**ADC Planning Consultation
Response from the Historic Buildings Adviser**

Application Number	H/2/12/L and H/2/12
Address	2 St Nicholas Cottages, Houghton
Description	Internal alterations & renovate conservatory.
Case Officer	Anita Gardner
Site Visit

No Objection Subject to Amendment

2 St Nicholas Cottages
Proposed floor plan 2012
Scale 1:50
Ref: H/2/12/L
Renovation + alteration
Mr and Mrs. S Smith

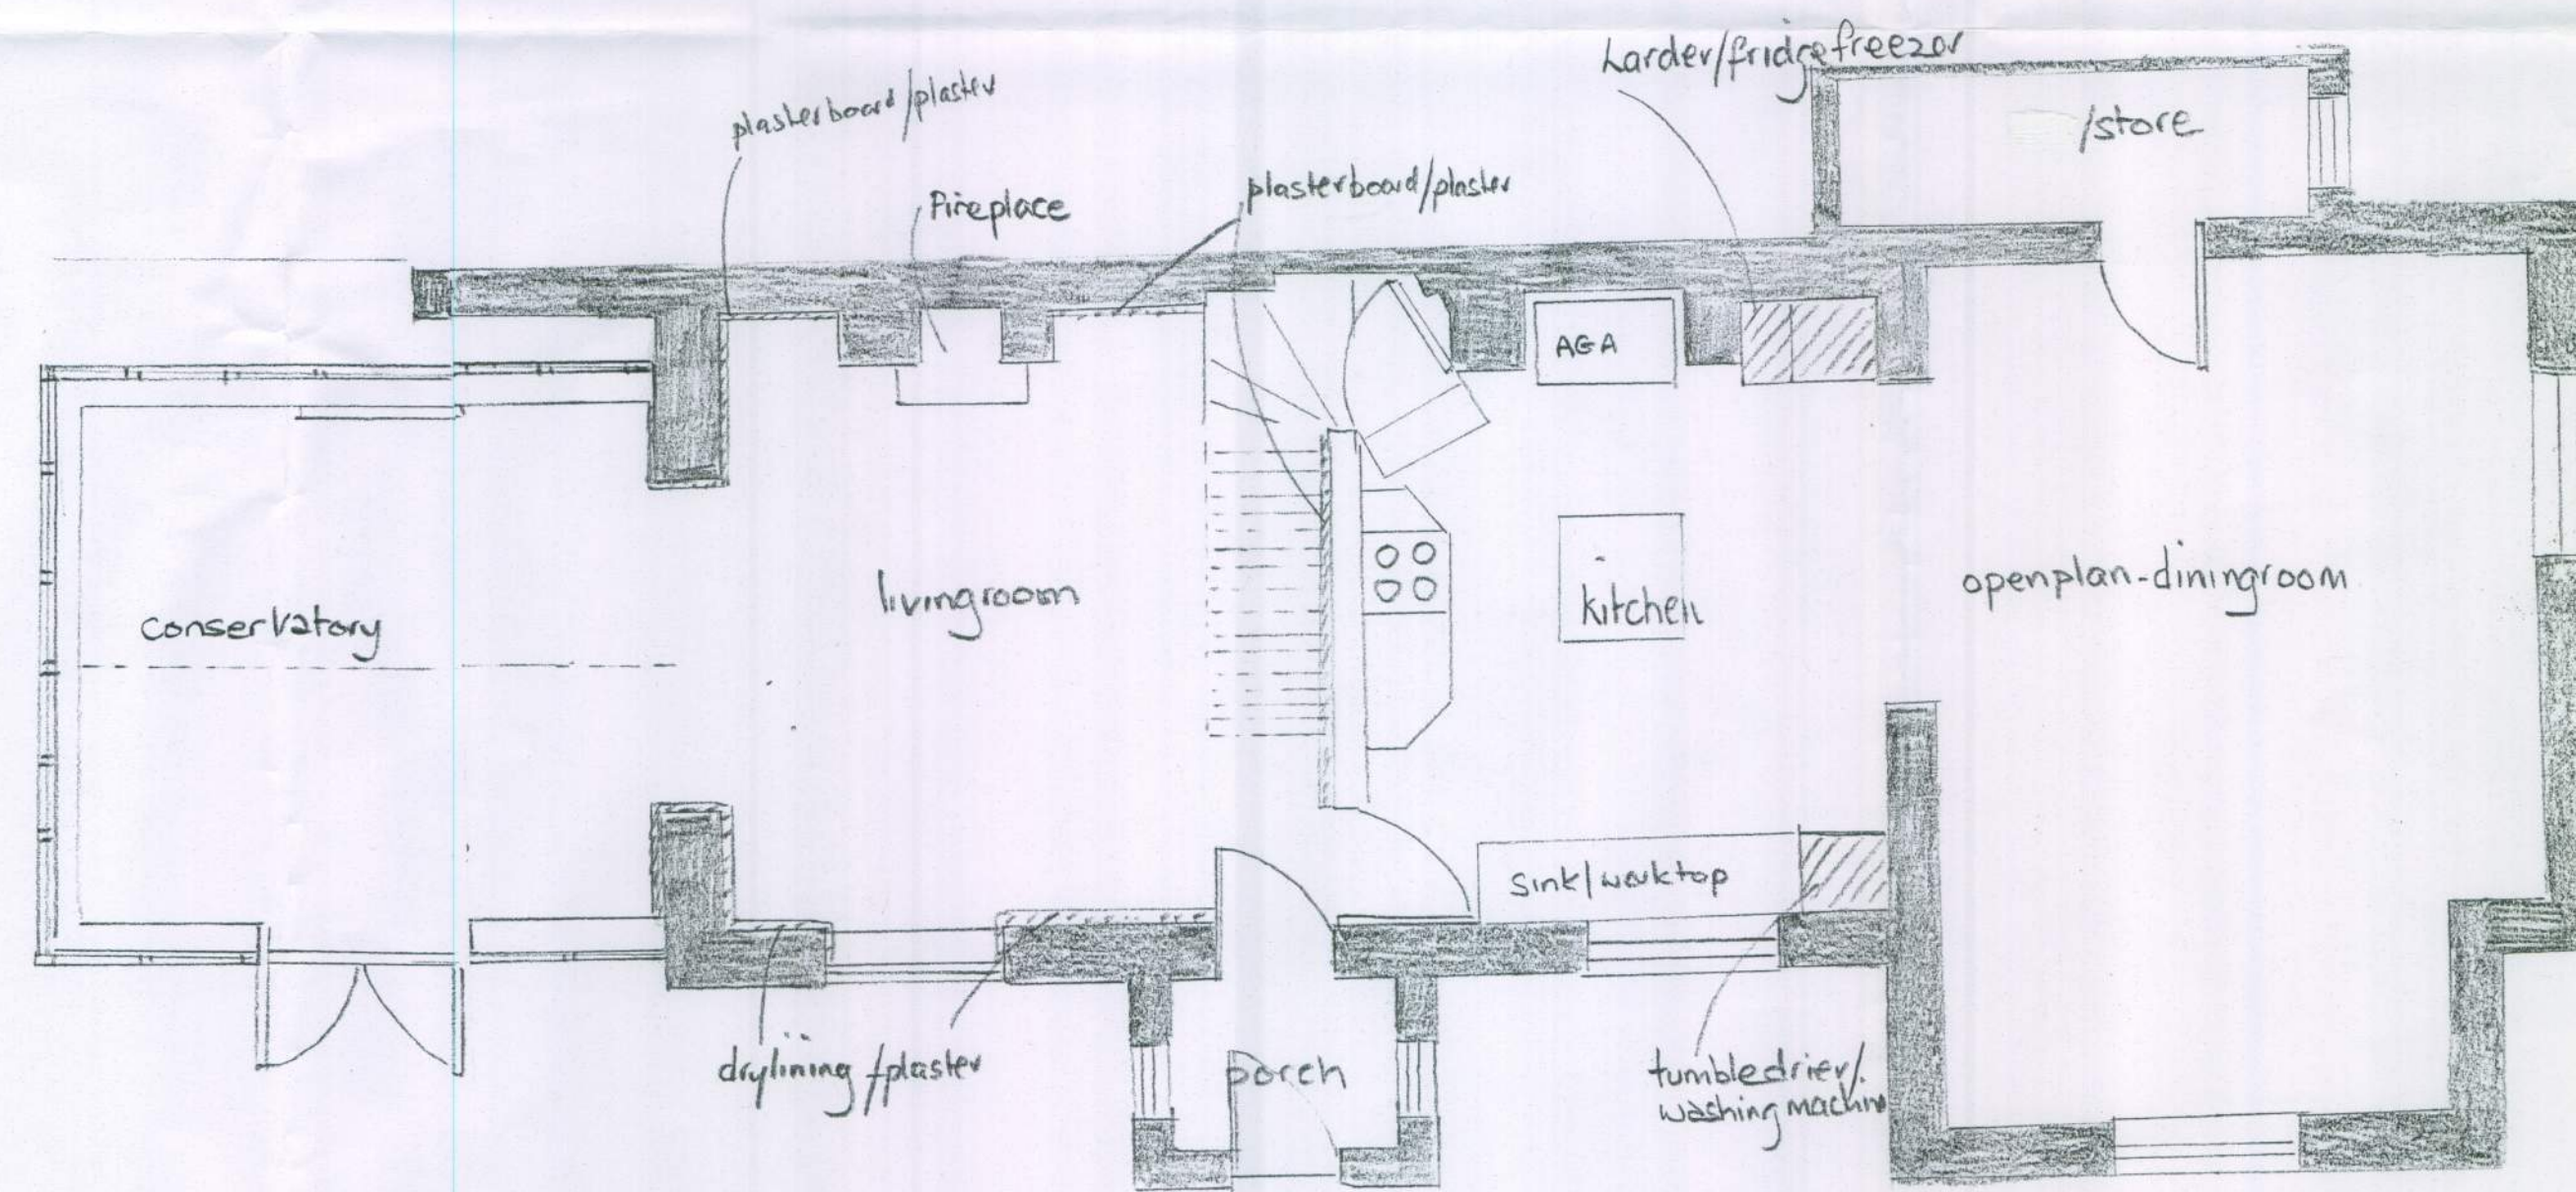
There is no particular concern with the replacement conservatory, or the removal of the stud wall in the later addition. There is an issue however with the widening of the original wall into the conservatory. At present this opening reflects the width of the French doors which is normally an appropriate size for a breach. Any opening beyond this can impact on the building plan but more importantly can alter the character of the historic space and result in the loss of historic fabric. In accordance with English Heritage guidance these types of harm should be kept to an absolute minimum.
